From: Niland, Mark
Sent: 25 June 2024 11:30
To: _planningadvice
Subject: FW: 1096-23 - Land between A16 and Rangell Gate, Spalding - Proposed Anaerobic Digester Plant

H16-1096-23 - Land between A16 and Rangell Gate

From: Samantha Legg <Samantha.Legg@lincolnshire.gov.uk>
Sent: Tuesday, June 25, 2024 10:53 AM
To: Niland, Mark <Mark.Niland@sholland.gov.uk>
Cc: DevelopmentManagement <DevelopmentManagement@lincolnshire.gov.uk>
Subject: 1096-23 - Land between A16 and Rangell Gate, Spalding - Proposed Anaerobic Digester Plant

Project PROPOSED AD PLANT		
Address NAYLOR FARMS RANGELL GATE, SPALDING LINCOLNSHIRE		
Client NAYLOR FARMS		
Drawing PROPOSED SITE PLAN		
Date DEC 2023	Scale 1:500 @ A1 - 1:1000 @ A3	
Project No. 3899B	Drawing No. P01	Revision

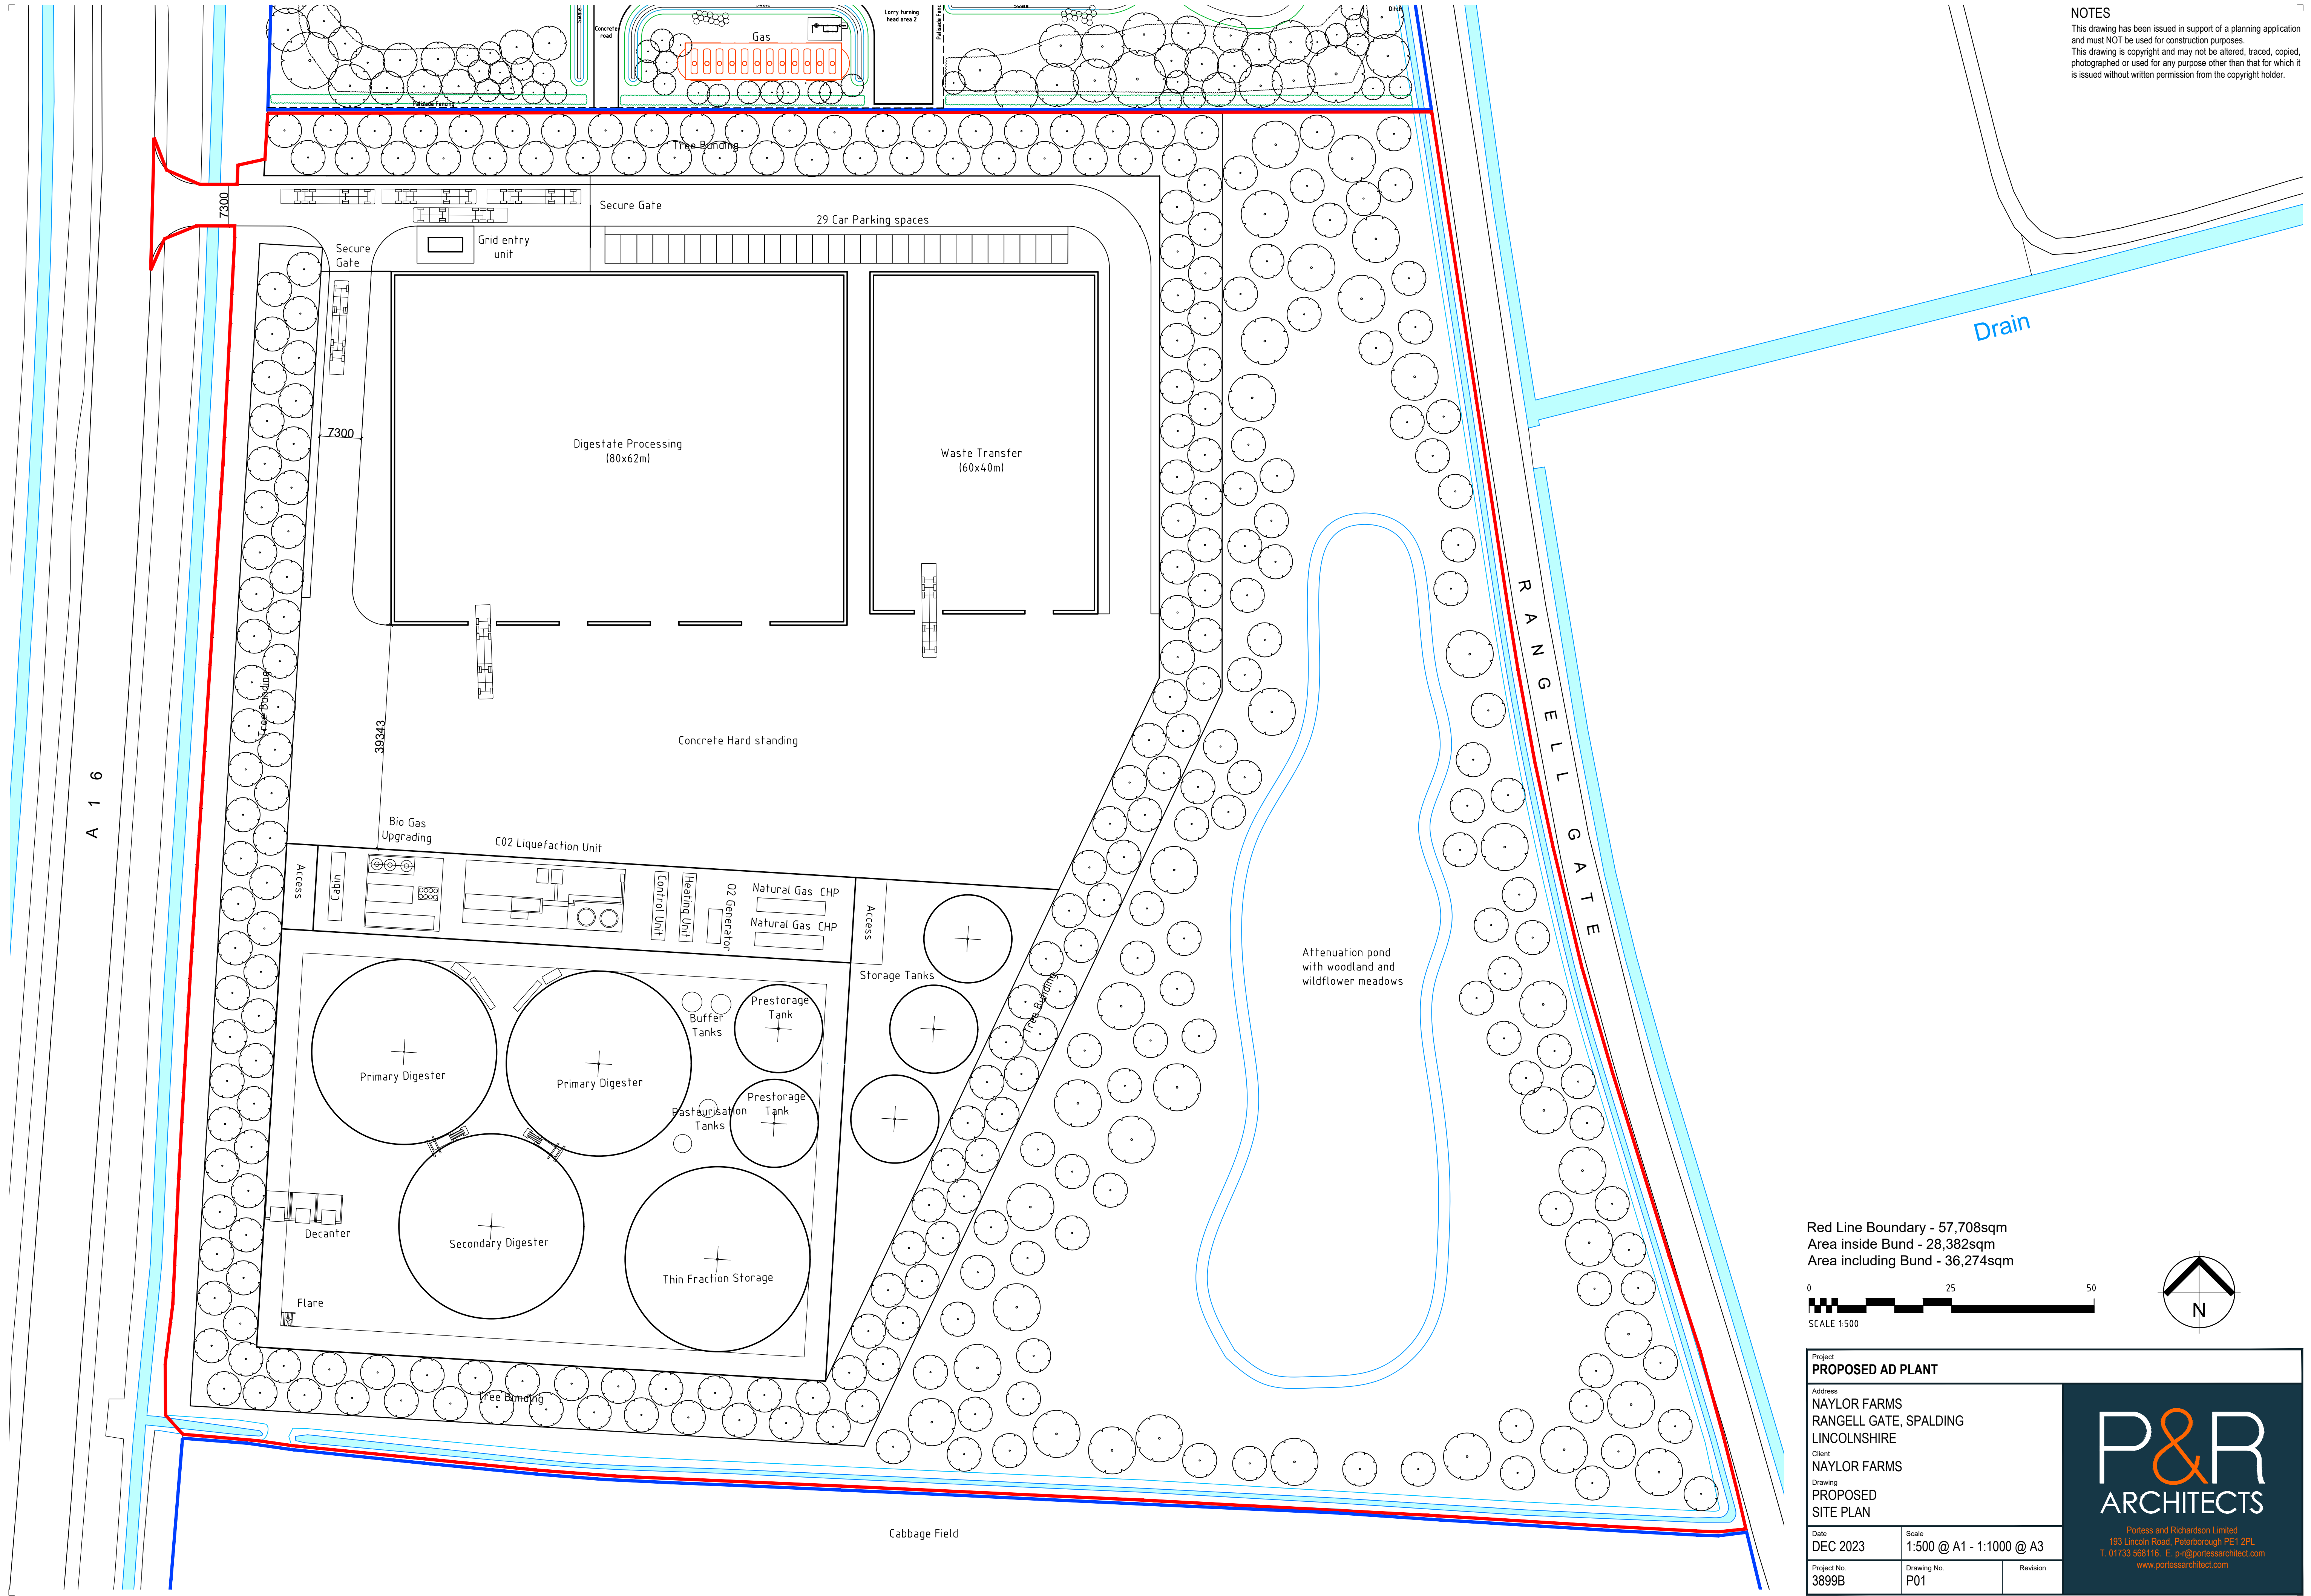
The drainage strategy drawing has been submitted but a written report should accompany this as it is a major application. The written drainage strategy should detail all methods of SuDs and justification as to why they can or cannot be incorporated into the site. A ground investigation report should supplement the report along with infiltration testing to BRE Digest 365. They need to submit any approvals required from the IDB. The access location will cross a watercourse so will need approval to culvert.
